# **EAST YORKSHIRE SOLAR FARM**

**Applicant's Additional Responses to Examining Authority's  
First Written Questions and Interested Parties' Submissions to  
First Written Questions at Deadline 1**

**Document Reference: EN010143/APP/8.27**

FIGURE TITLE
Potential Representative Viewpoint Locations
Sheet 1 of 2

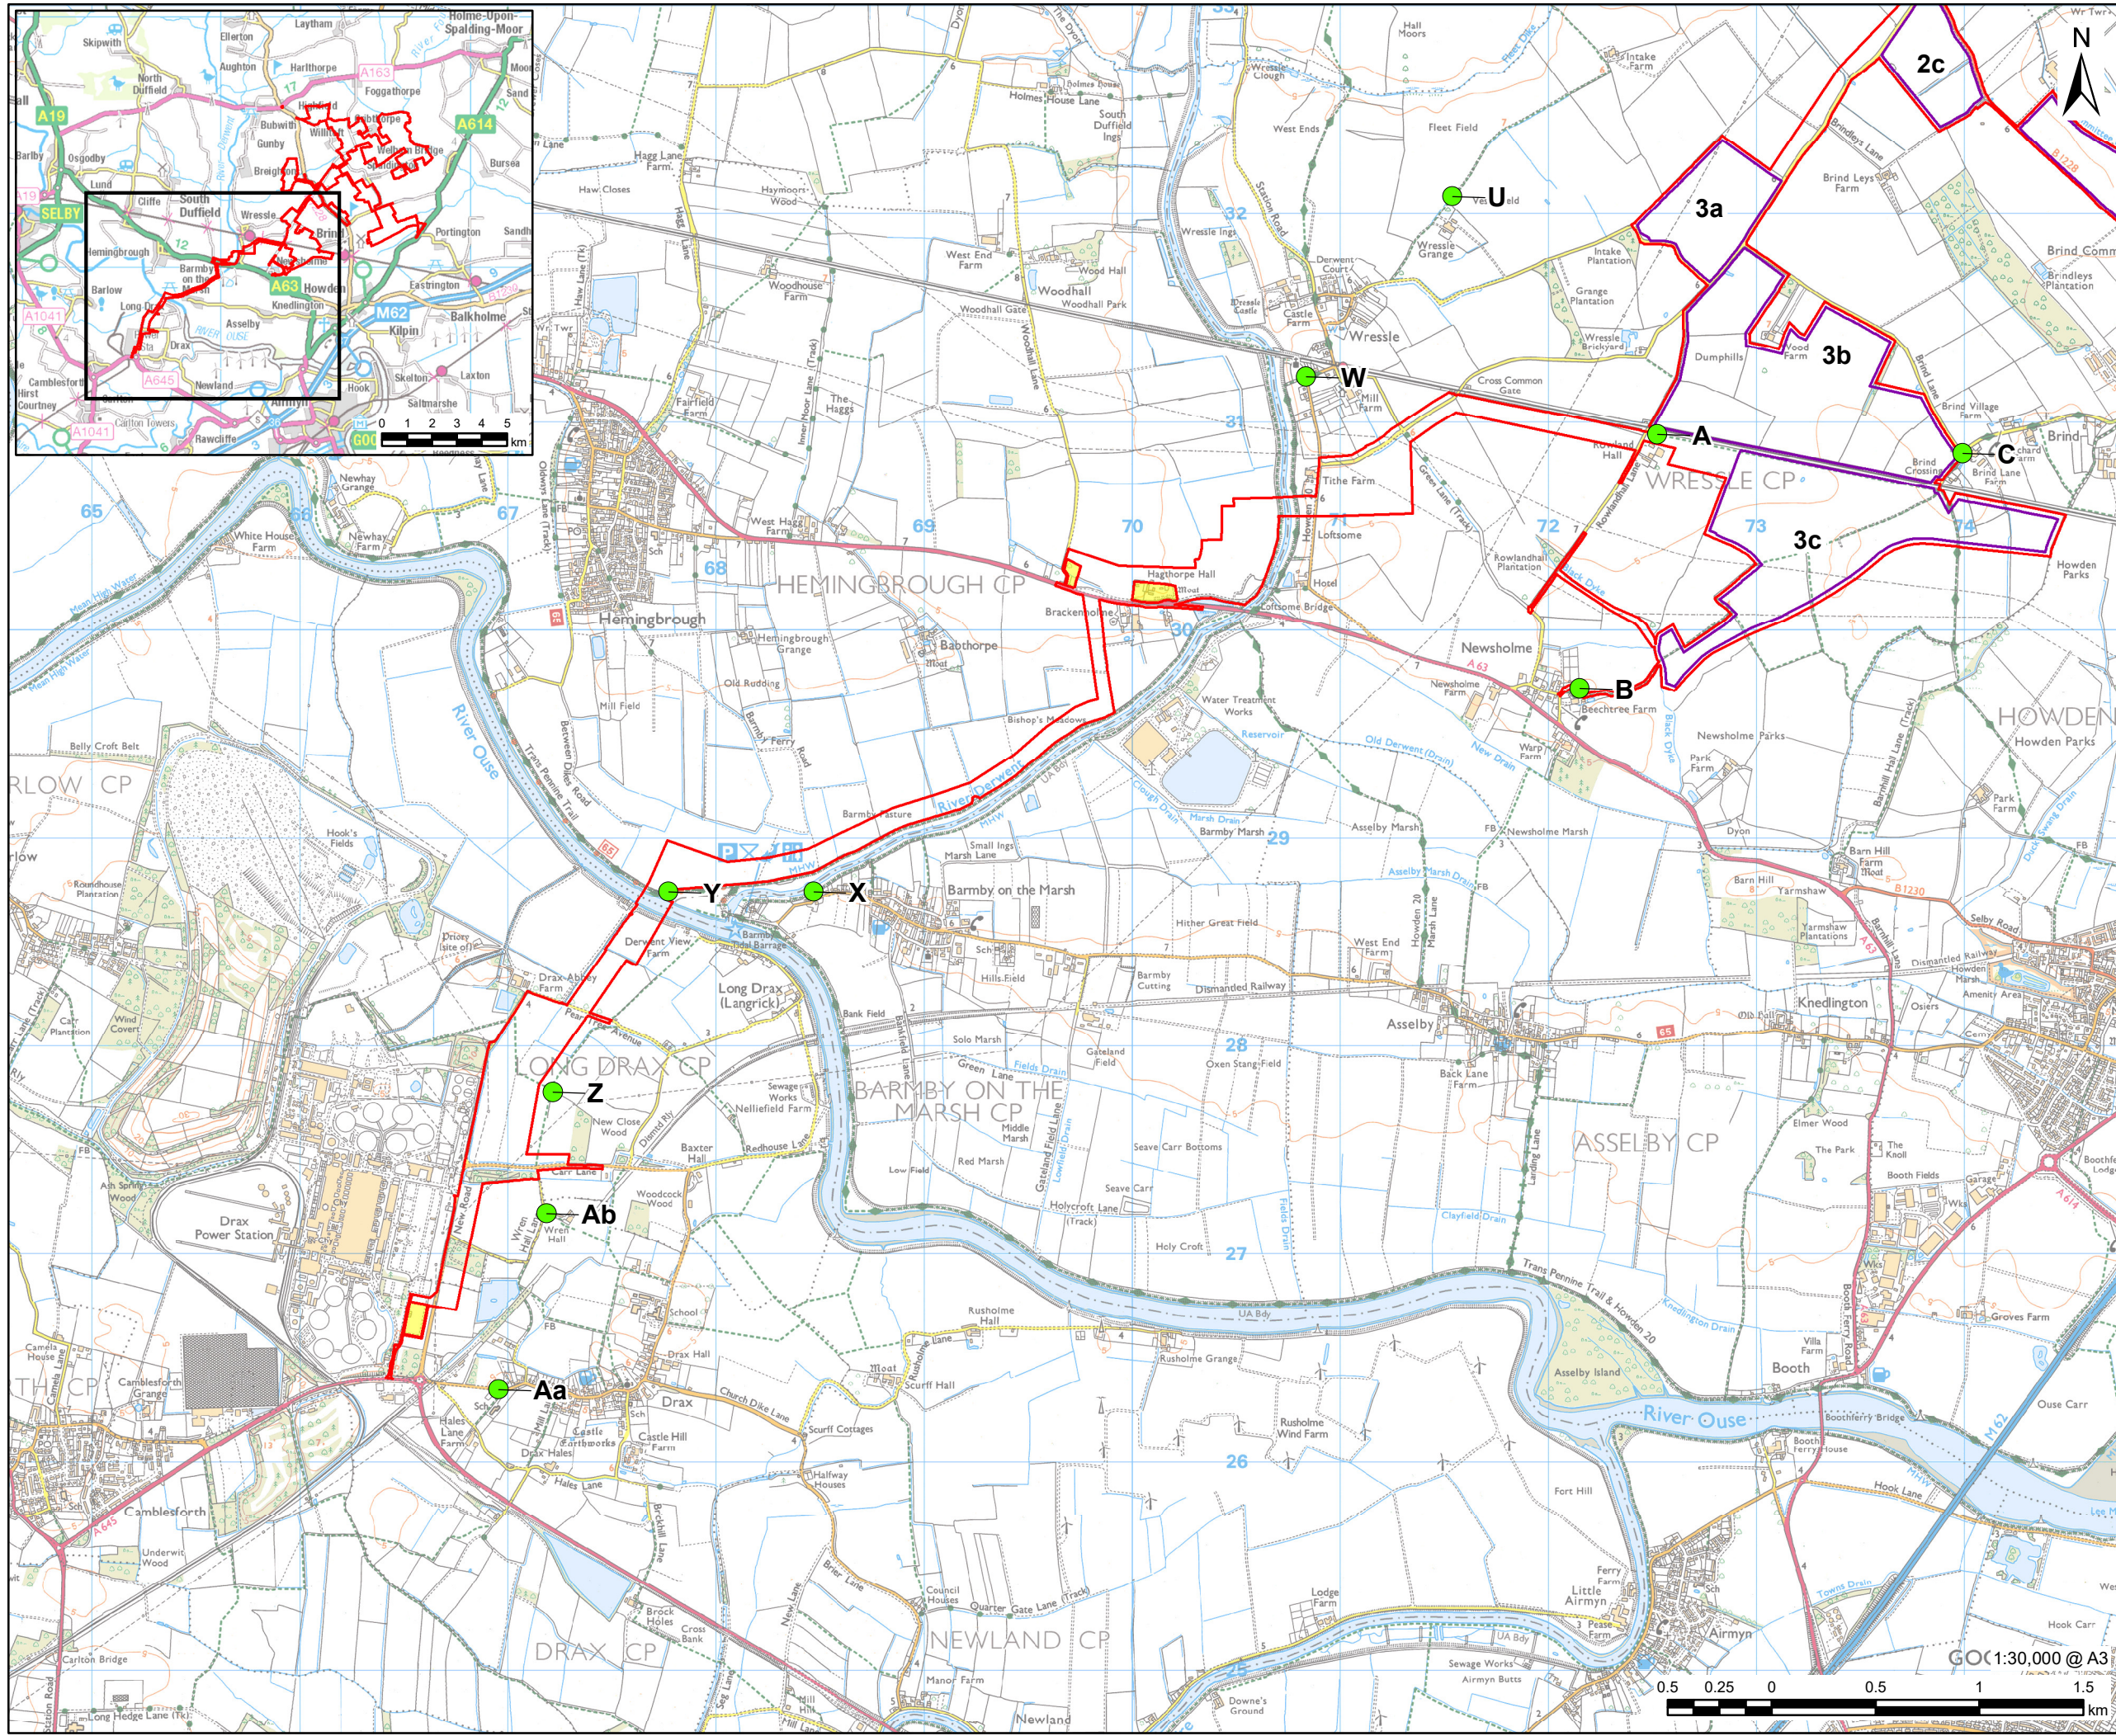
Q9.0.1	North Yorkshire Council	ES Table 10-1 page 10-11 and ES 10.3.6-10. Please comment on the selection of representative viewpoints	<p>The Applicant has not provided an additional viewpoint on New Road / Wren Hall Lane to explain potential vegetation loss, which is contrary to our previous request. This would have potential for a corresponding photomontage. Given the wide scope and parameter for work currently set within the Grid Connection Corridor we are not confident that the Applicant is being clear and assessing and illustrating the worst-case scenario. The Applicant has excluded this viewpoint on the basis that no vegetation will be lost, but this seems unlikely to be the case. For example, the LVIA includes statements that no vegetation will be lost as a result of the scheme (e.g. paragraph 10.5.83 of the LVIA). However, trees and hedgerows are shown for removal on the Tree Protection Plans within the Arboricultural Impact Assessment (Application Document ref.</p>	<p>An additional viewpoint on New Road/Wren Hall Lane was discussed at a pre application meeting regarding landscape and ecological matters held on 1<sup>st</sup> August 2023 between the Applicant and East Riding of Yorkshire Council and North Yorkshire Council representatives. This was proposed in the context of the potential for existing vegetation loss in this location as a result of the Scheme. Following a review confirming existing vegetation would be retained at this location, it was not considered relevant by the Applicant to include this as an additional viewpoint and prepare a corresponding photomontage as part of the assessment</p>

ExQ1	Respondent	Question	Response at Deadline 1	Applicant's Response at Deadline 2
			<p>APP-102, APP-103, APP-104). Additionally, these impacts are not fixed to specific cable route alignment within the Grid Connection Corridor, with impacts to be reassessed and included as part of the detailed CEMP, Table 6 page 73 (CEMP DCO Requirement 11). We are not confident that tree protection will be an active part of the future design development for the main connecting cables, temporary access and compounds within the Grid Connection Corridor and a requirement of the Detailed design approval (Requirement 5 of the DCO).</p>	<p>presented in Chapter 10: Landscape and Visual Amenity of the ES <b>[REP1-014]</b>.</p> <p>The Applicant has updated the Framework LEMP <b>[REP1-063]</b> as part of the Deadline 1 package of information to make it clear that areas of existing vegetation within the Grid Connection Corridor, specifically in proximity to Drax Power Station, will be retained and protected. The update sets out the measures to be undertaken to minimise impacts upon existing vegetation and hedgerows within the Grid Connection Corridor including, where possible, the reduction in working width to approximately 5 metres when the route passes through vegetation and hedgerows. The Applicant will determine the route of the Grid Connection Cables following trial trenching, as set out in the Overarching Written Scheme of Investigation (submitted to examination at Deadline 1 <b>[REP1-086]</b>), and any ground investigation work is undertaken as described in Table 14 of the Framework CEMP <b>[REP1-053]</b>. The update has also been made to the Landscape Masterplan presented at Appendix A of the Framework LEMP <b>[REP1-063]</b> to illustrate the retention of existing vegetation. These updates have been submitted into the examination at Deadline 1.</p> <p>The protection of trees in relation to the route of the Grid Connection Cables is addressed in detail in Section 4.5 of the Arboricultural Impact Assessment report [APP-102] and this sets out how the design will be amended where possible to avoid cable routes or access routes incurring within the Root Protection Area of retained tree features and where avoidance is not possible how it will be managed in principle. The final extent of incursions and the methodology for any such work will be detailed as part of an Arboricultural Method Statement which will be secured as part of the detailed CEMP. This is described in Table 6 of the Framework CEMP <b>[REP1-053]</b>.</p> <p>The detailed CEMP and a detailed LEMP will need to be approved post consent prior to construction by the relevant local authorities. These detailed management plans must substantially accord with the framework management plans the Applicant has prepared and this is secured by requirements in Schedule 2 to the Draft DCO <b>[REP1-006]</b>.</p> <p>The assessment within Chapter 10: Landscape and Visual Amenity of the ES <b>[REP1-014]</b> has therefore been undertaken on the assumption that areas of woodland along</p>
